SHEET:
SITE PLAN

JOB NO: 18-223-HOTCHKISS DATE: 06.10.2019
 PHASE: CD
 JOHN HOTCHKISS COMMERCIAL OFFICE DRAWN BY: RLK
 2290, 2294 OLD RANCH RD COLORADO SPRINGS

Add PCD File No. PPR203

VICINITY MAP

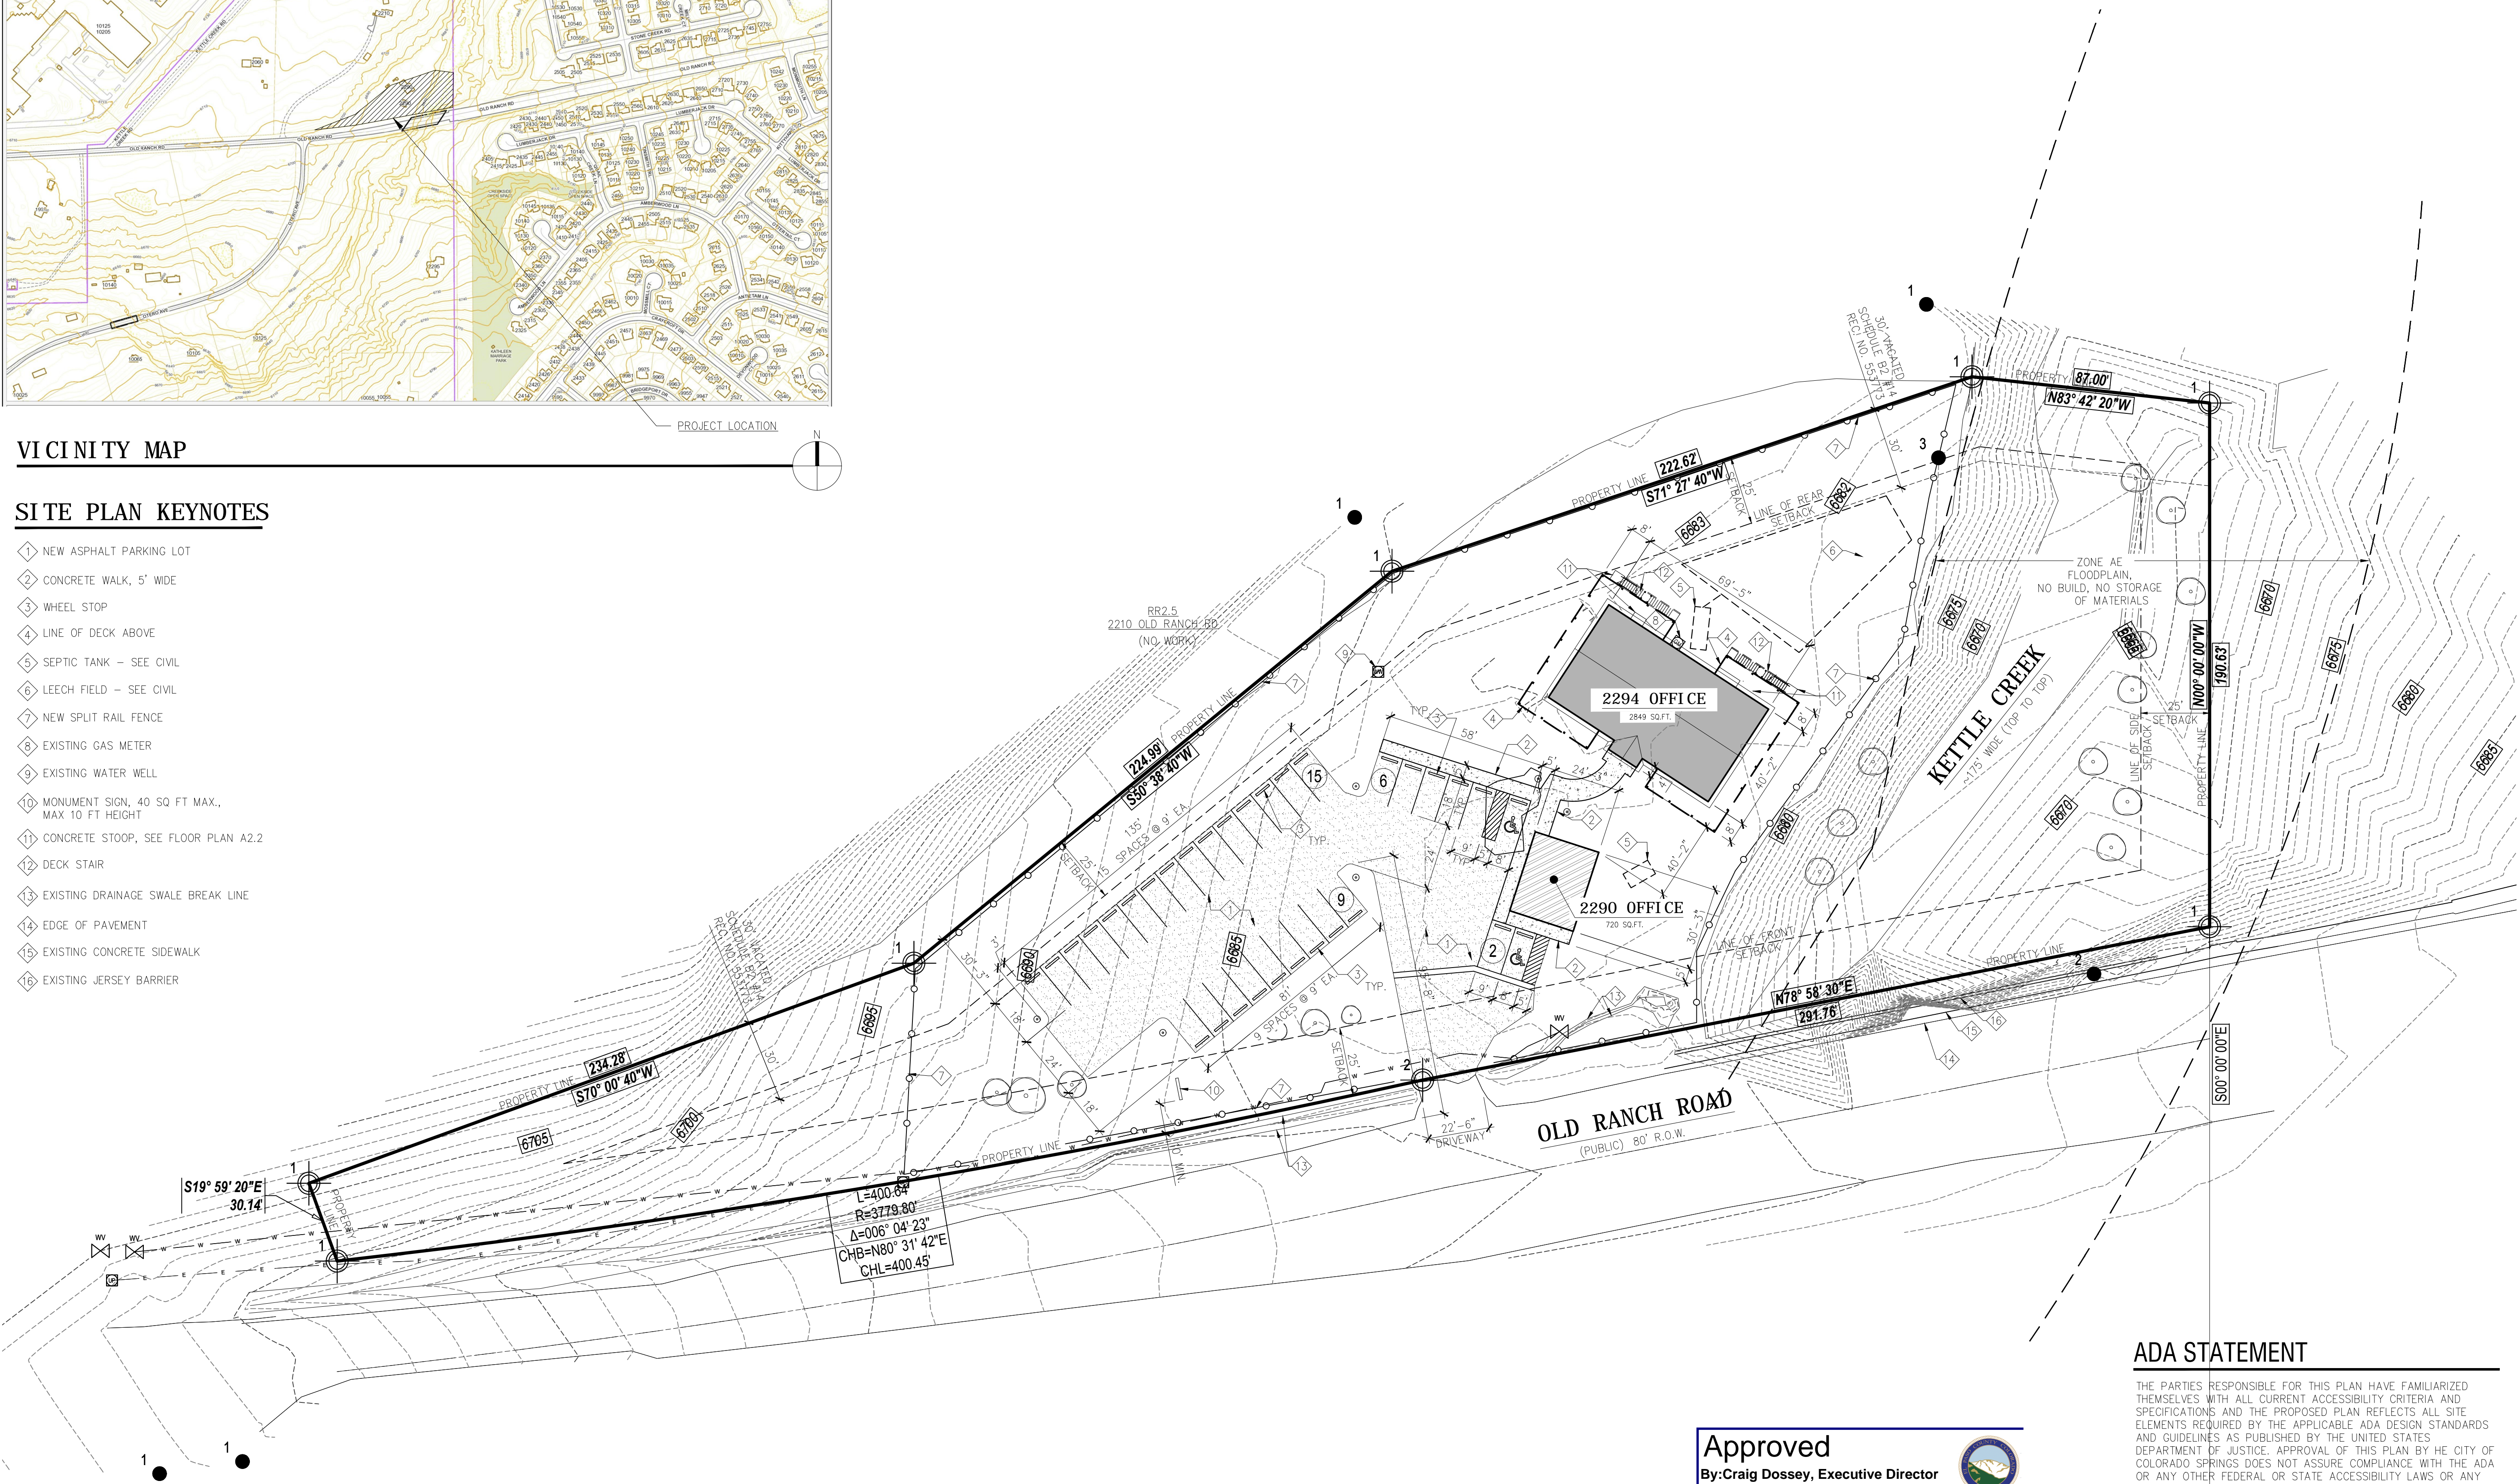
Provide a vicinity map on the plan

Show and label all existing easements affecting the property. Title commitment lists several easements that are not denoted on this plan.

Please label this as: Zone AE Floodplain, No-build, no storage of materials

Either reduce size of building or move building out of the setback. If you are seeking a dimensional variance, you will need to justify how these are not possible options and apply for the variance through the BOA process. For an encroachment of less than 20% of the requirement (5 ft), administrative relief may be considered.

Per Table 6-2, professional offices require 1 parking space per 200 sq. ft. 6,420 sq. ft. of professional office use requires 32 parking spaces. Only 30 have been provided.

Sign permit required. Approval of sign size, placement, or location not conferred via site plan approval.

Indicate the width of the driveway

Please identify what this is.

Please label the existing sidewalk, jersey barrier, and guardrail.

Please label the existing utilities on the plan and/or in your legend

Please identify what these lines are.

Please also include the parcel #
